Re: Application No. 08_0194 MOD 4

I object to this application because:

**APPENDIX 1**  
**FIGURE 3**  
 PREPARED: BW  
 DATE: 23 August 2012  
 FILE: N97017\_Base.dwg

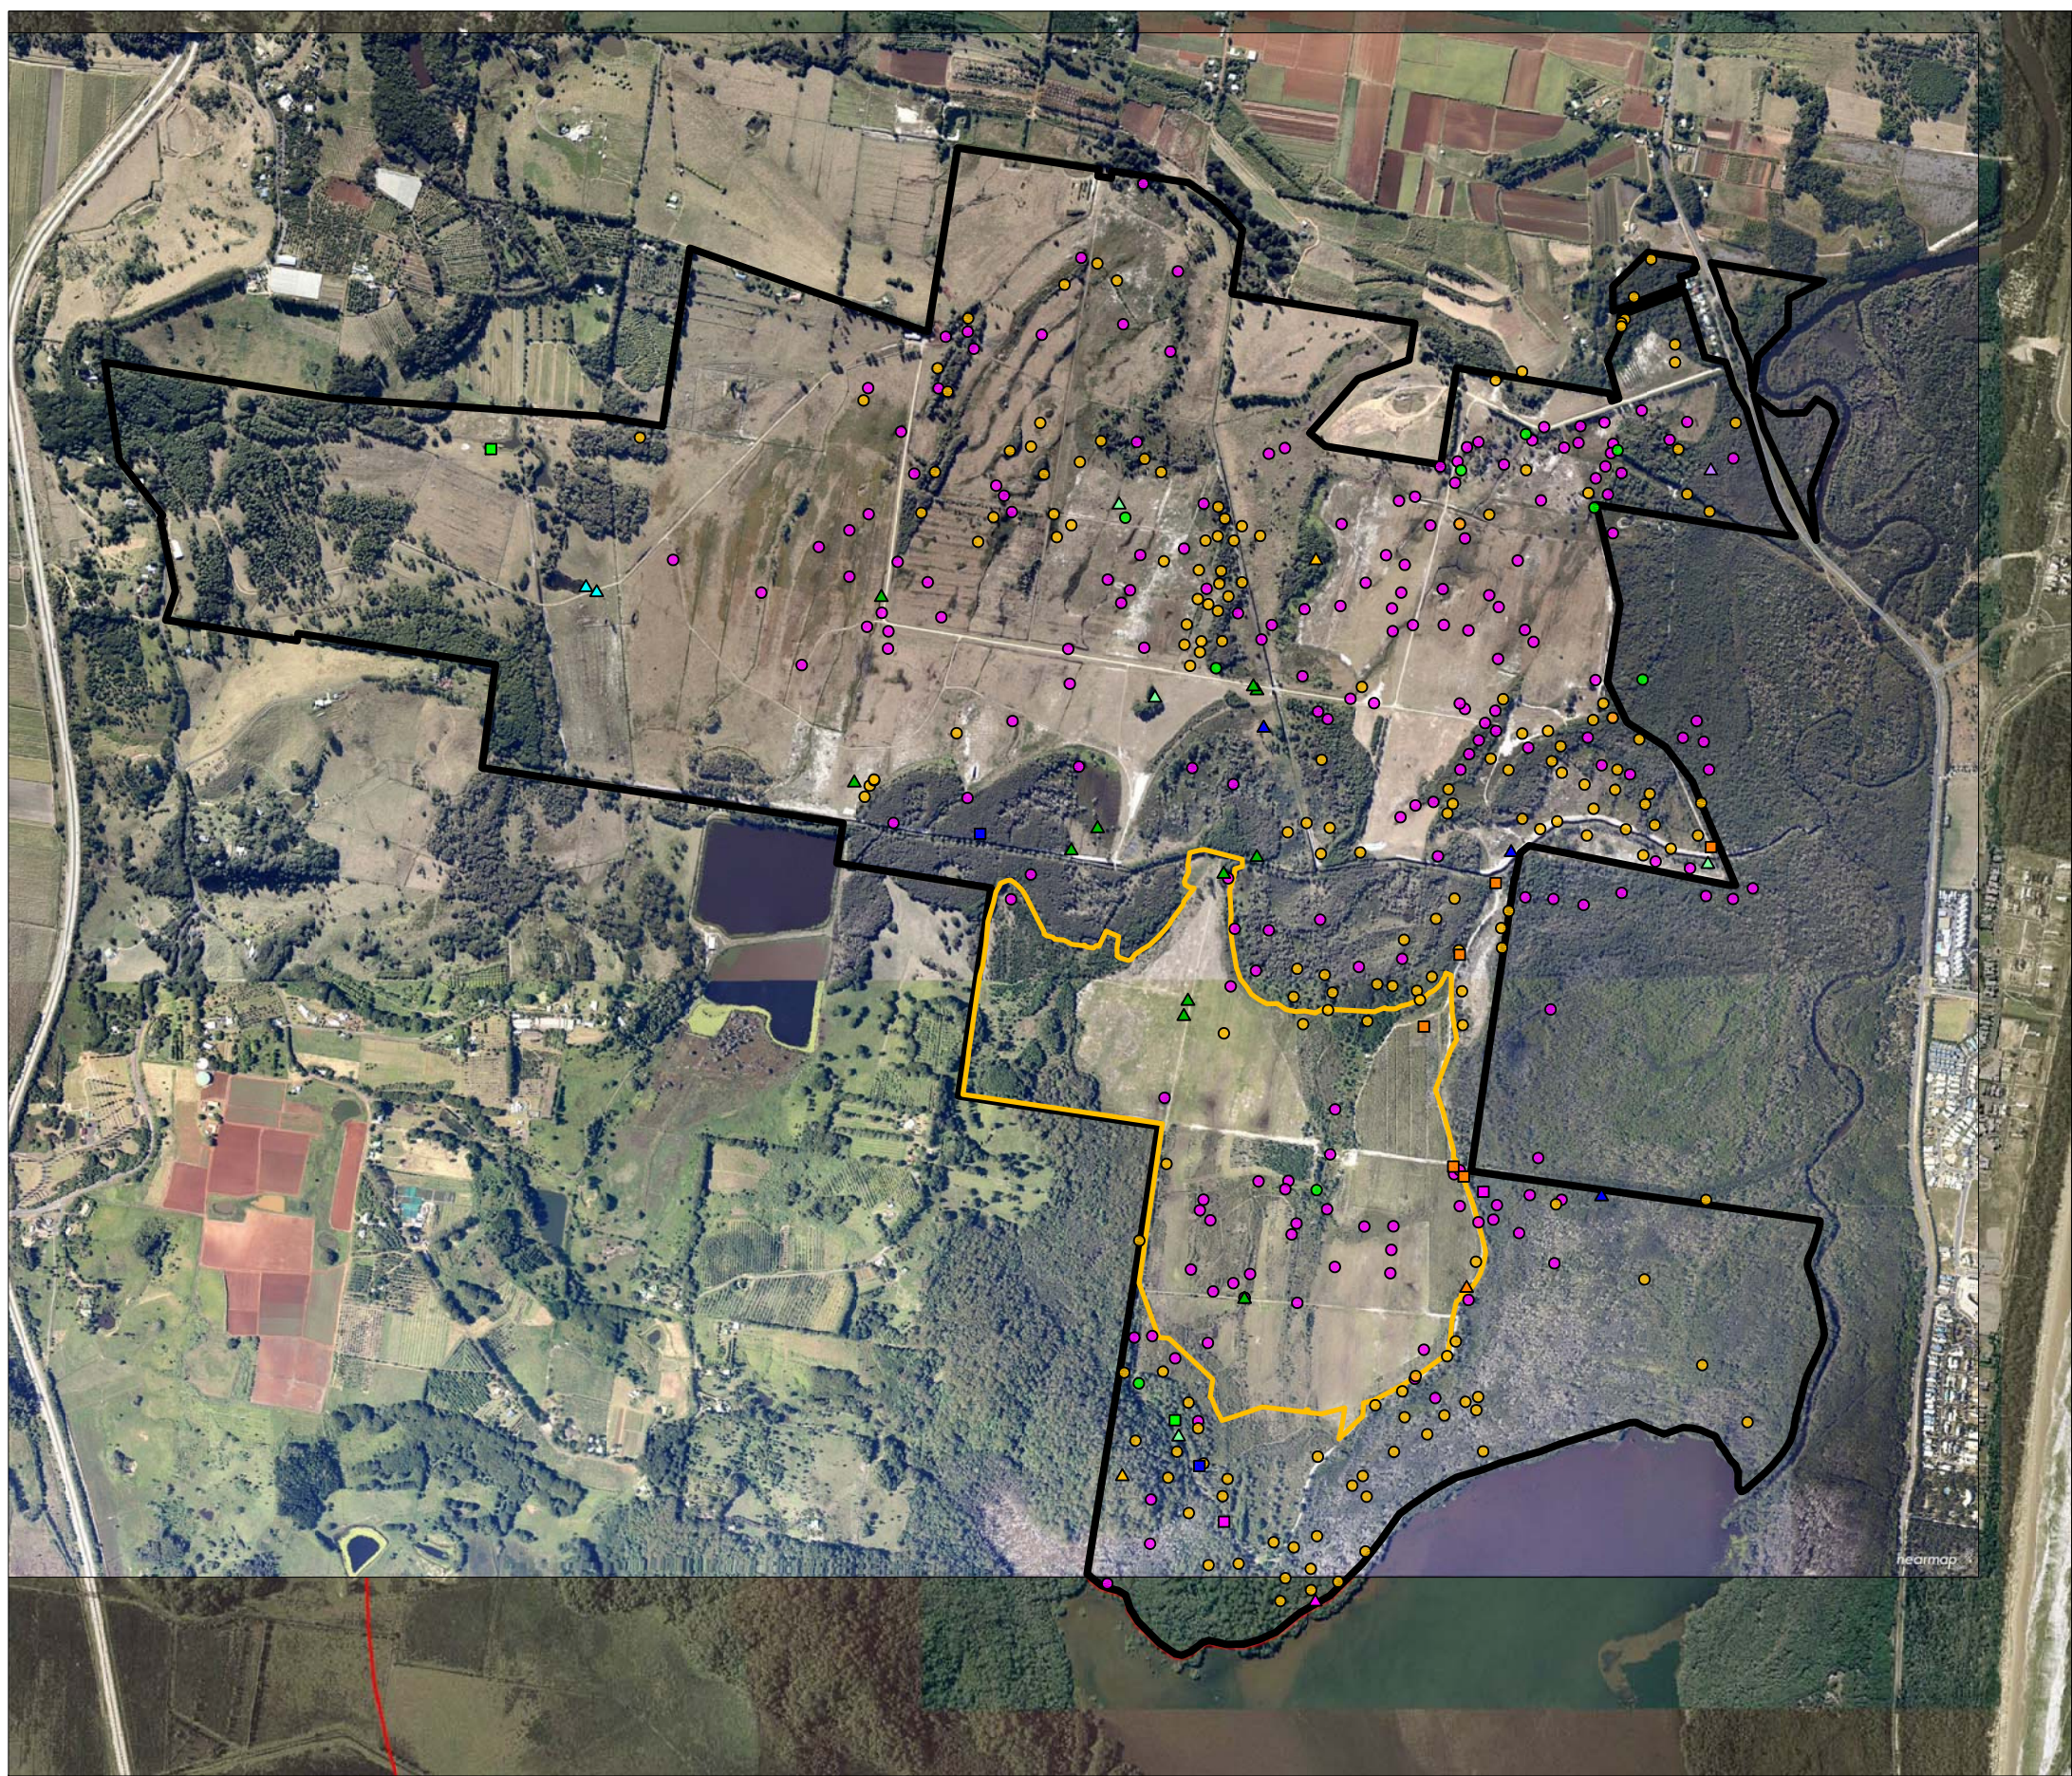
2. The applicant has stated that some areas previously designated to be compensatory habitat are “not suitable for compensatory habitat as already contains Secondary Koala habitat” (Figure 3 of the application). Primary food trees should be planted in those areas if it could enhance their value to koalas. Enhancement of those areas by adding primary food trees might be important to the survival of the koalas impacted by the proposed development.
